Comments on AL/75/12 and to AL/76/12/DOC

We would like to make the following comments regarding planning application AL/75/12 and to AL/76/12/DOC.

EAST ELEVATION - 1:100

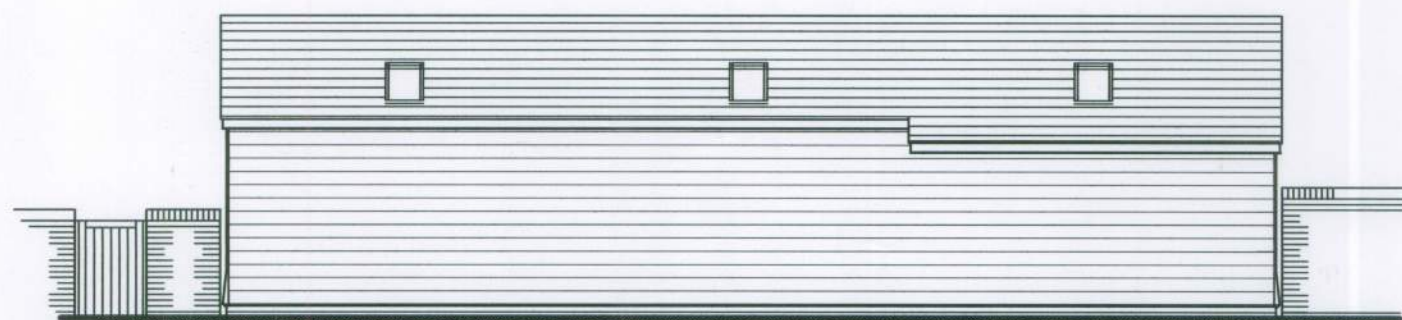
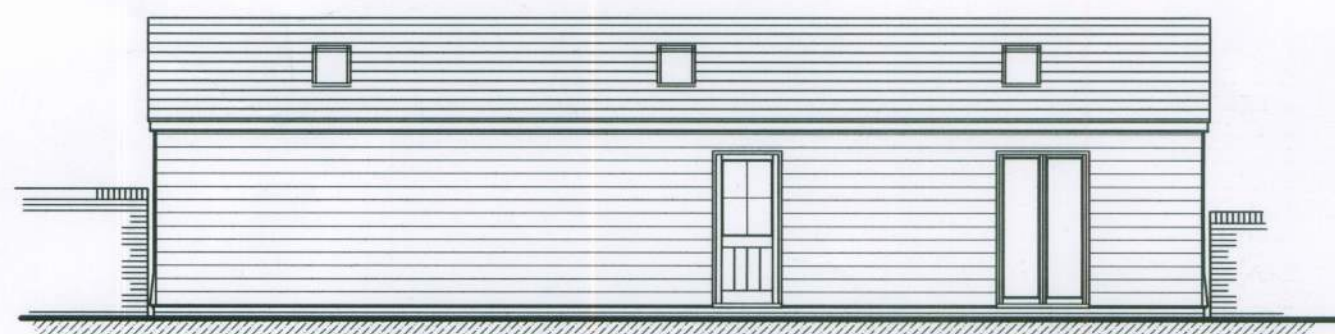
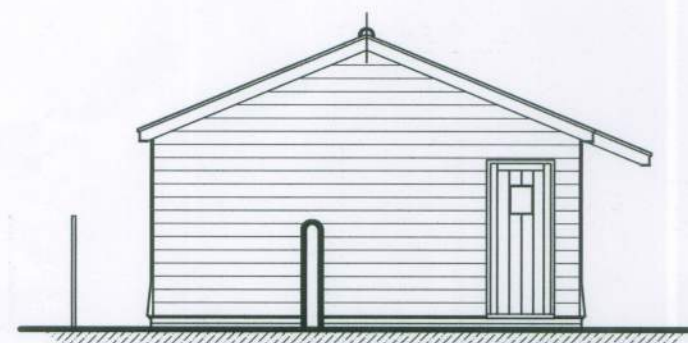
We also note that the drawings submitted are not accurate in respect of the position of openings on the flint and brick wall at the South East end of the building.

We object to the changes to fenestration. It is clear that original openings must be retained since this building is in a conservation area. This rule has been applied to our building and to other buildings on the site and so the same should be applied to East Barn. The current openings are significantly different from those on the approved plans in style and size. These rules need to be applied equally to all properties on the site.

The bin canopy on the North elevation not only significantly changes the appearance of the building but it also presents a risk to pedestrian users of the access road. There is no wall, or fence to contain any materials stored under the canopy and so there will be a tendency for it to spread into the road. This access road is becoming increasingly busy with large and fast vehicles constantly accessing the site. Any pedestrians walking along the road will be forced to walk into the road, which is going to be unsafe considering the buildings on the site are intended for holiday lets, and so will have families staying. It is vital that access to the buildings is made as safe as possible for those families. The original plans show the bins and cycle rack being stored within the enclosed

boundary on the East end of the building. This is perfectly adequate so we fail to see the need for the bin canopy.

If the canopy is approved we would expect to see the bin store enclosed using a flint and brick wall to be in keeping with the rest of the site, and a restriction placed on what materials are stored under the canopy. ie. Only bins. However, with this, we are also very concerned that should approval be given for the bin canopy, this will merely encourage Mr May (or the current owners) to request planning for a more permanent structure or to increase the size and footprint of the house at a later stage. Furthermore, the original plans show that the area that is covered by the canopy was originally intended as a parking bay. Should the area no longer be available for use as a parking bay, where would that second vehicle be parked? There is very limited space next to the building given the nature and volume of traffic now using the site. The building seems to be predominantly used by the owner and his friends rather than being used as a holiday let, so we assume that visitors will require somewhere to park.

FLOOR PLAN 1:50

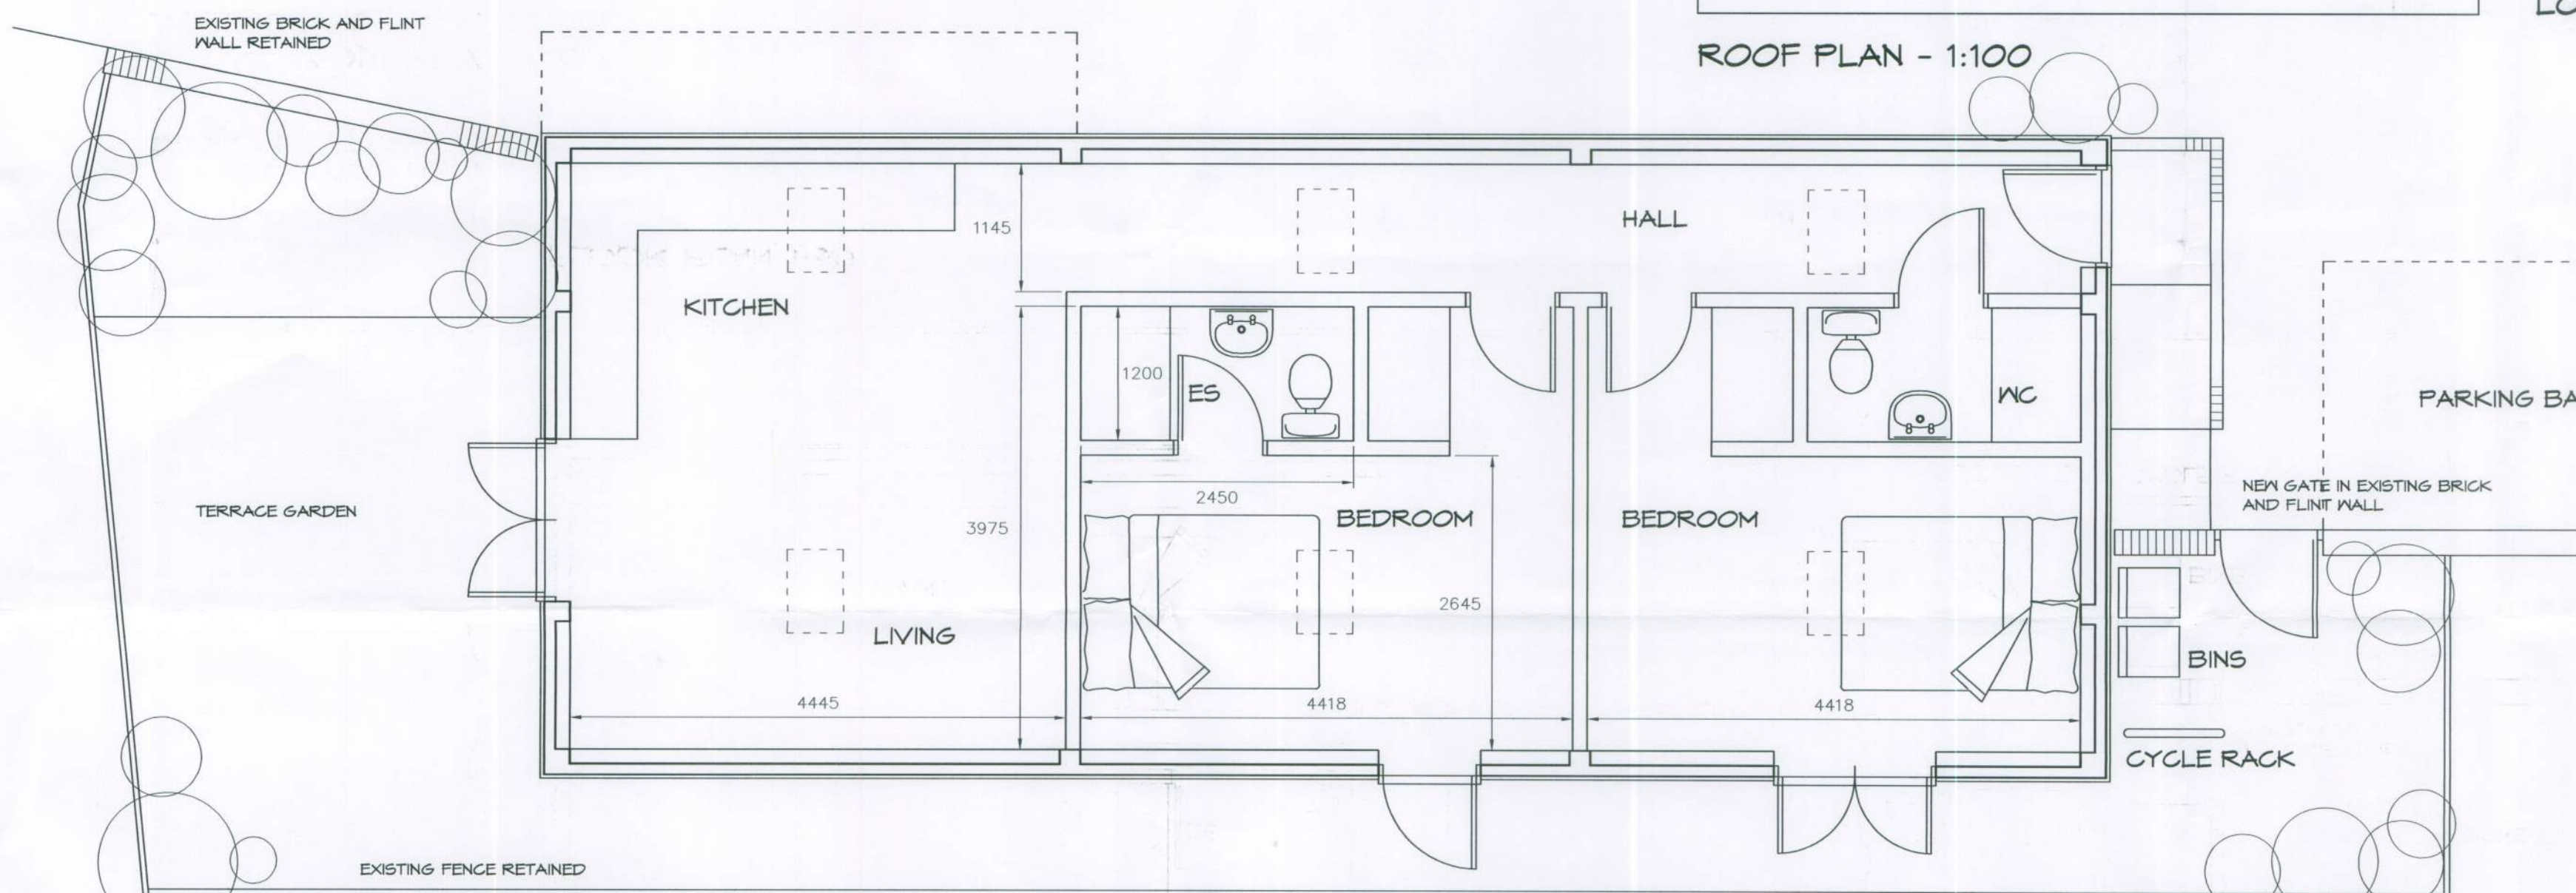
We assume that the cycle store will still be provided as shown in the original plans. This is not yet present.
